DECISION DELEGATED TO HEAD OF PLANNING

Application No: H13-1037-24 **Applicant:** R K Wilson Builders (MSE) Ltd

Proposal: Details of existing and proposed site levels, proposed floor levels, hard surfaced areas, garden/amenity areas, proposed boundary treatments and Biodiversity Net Gain Plan (Conditions 4, 5 and 8 of H13-0281-24)

Location: Rear Of Cassini Lodge 58 Seas End Road Moulton Seas End

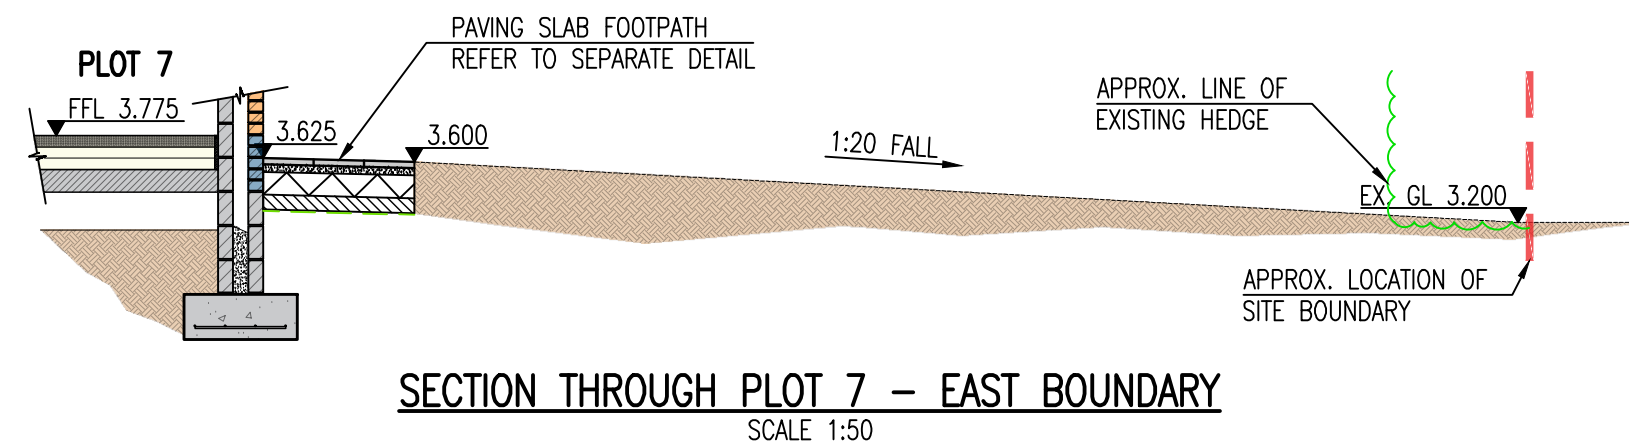
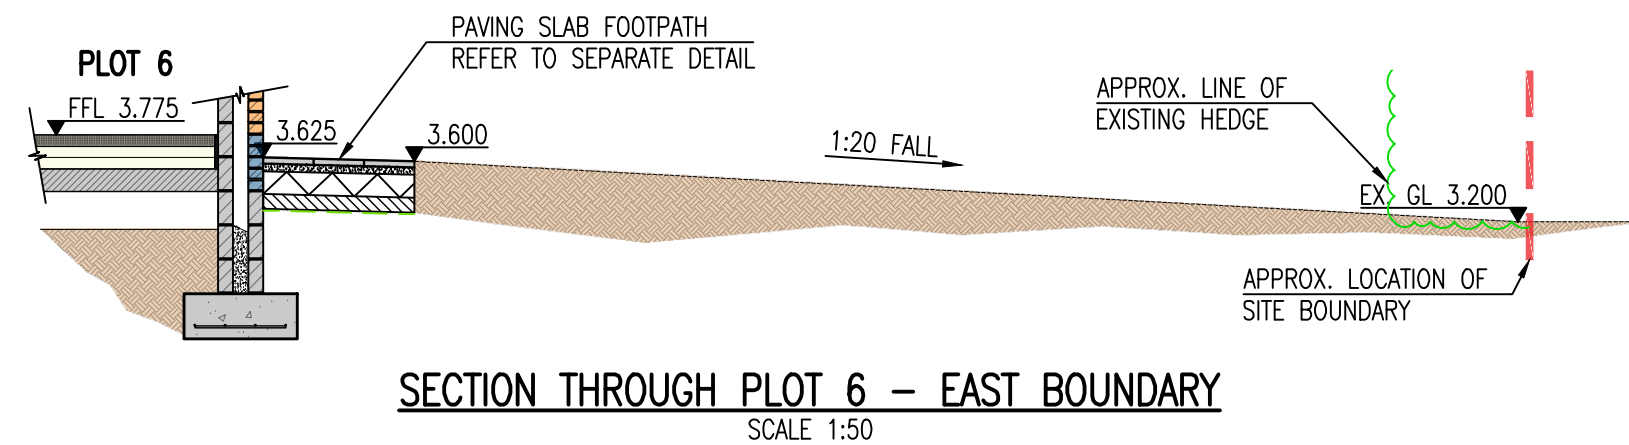
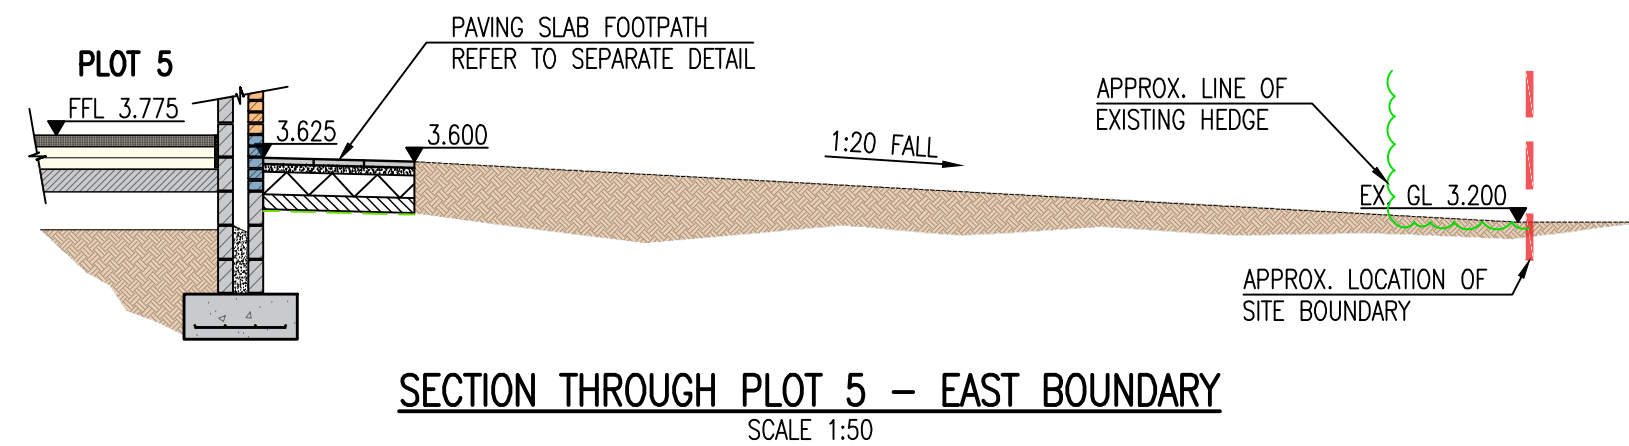
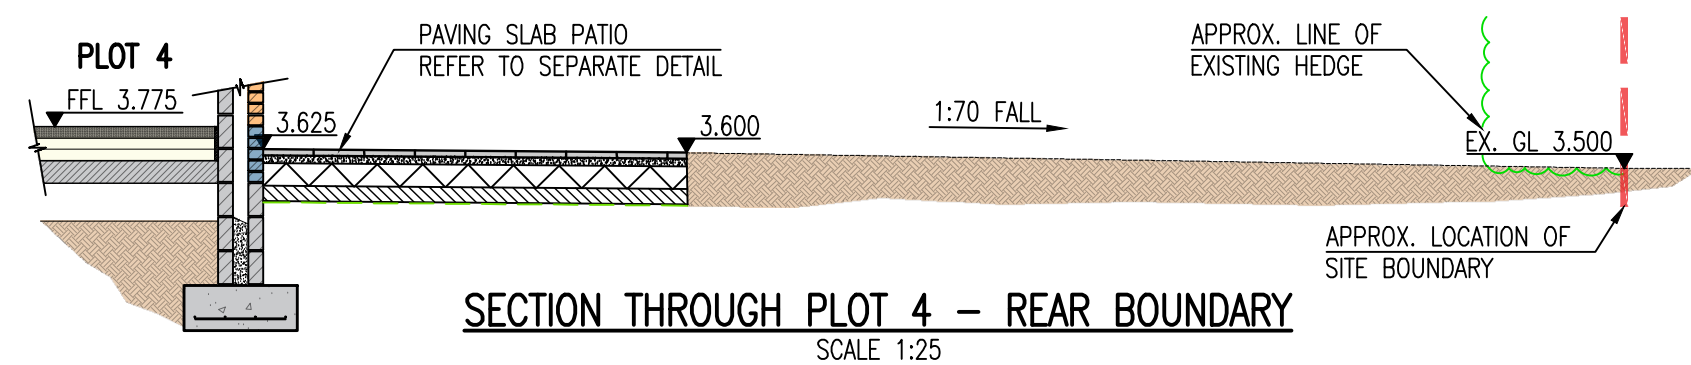
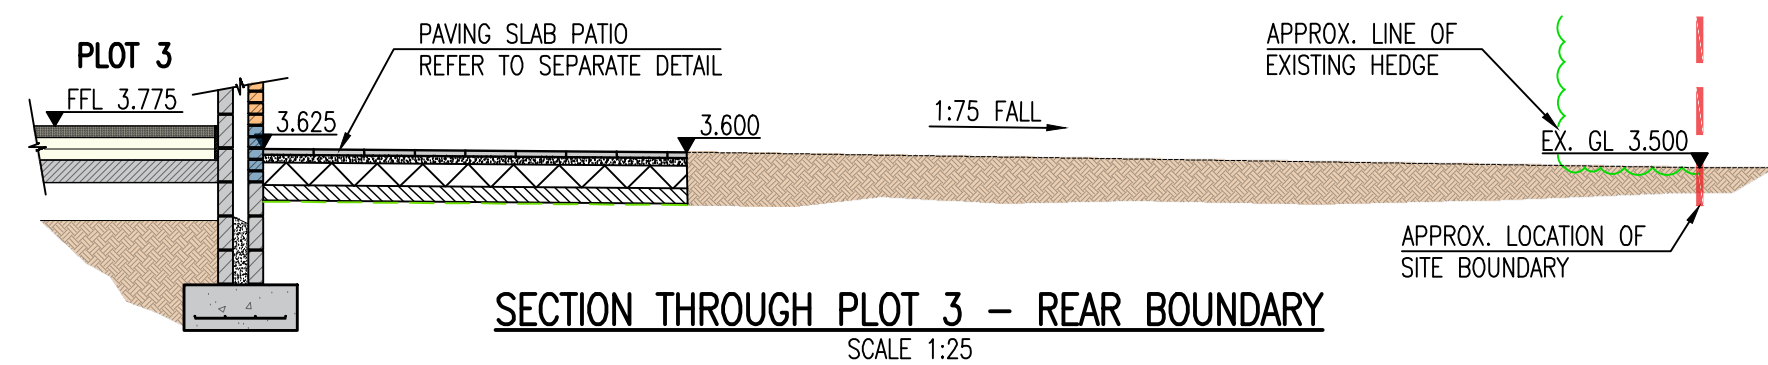
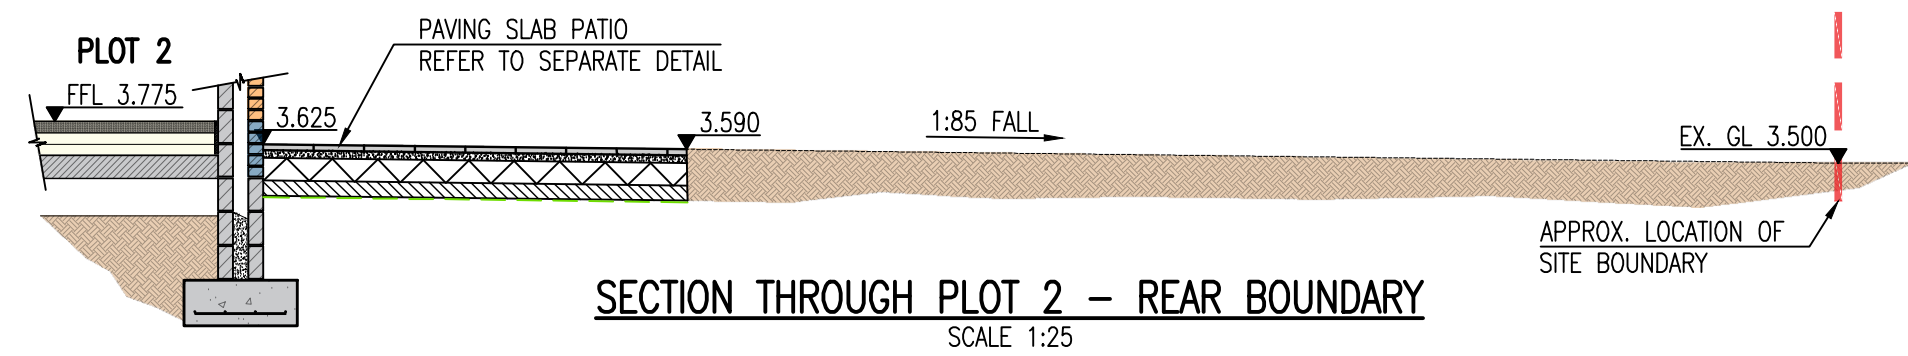
The levels shown on the plan are considered to be acceptable. The site section shows that the plots 1-7 (inclusive) each plot is set at 3.775m AOD. Plots 1, 2 and 3 represent a circa 300mm increase over existing levels whilst plots 4, 5, 6, and 7 are closer to 500mm increase. The closest dwellings to the application site are plots 4 & 5 at the south Edge of Macfie Close. The original permission for that application site (H13-1062-19) confirms that ground levels are higher than they are on this application site. Furthermore, those dwellings adjacent to this proposal are side facing, with a limited number of openings. Therefore, the impacts from this development are considered acceptable and site levels are therefore appropriate. Condition 4 is therefore discharged.
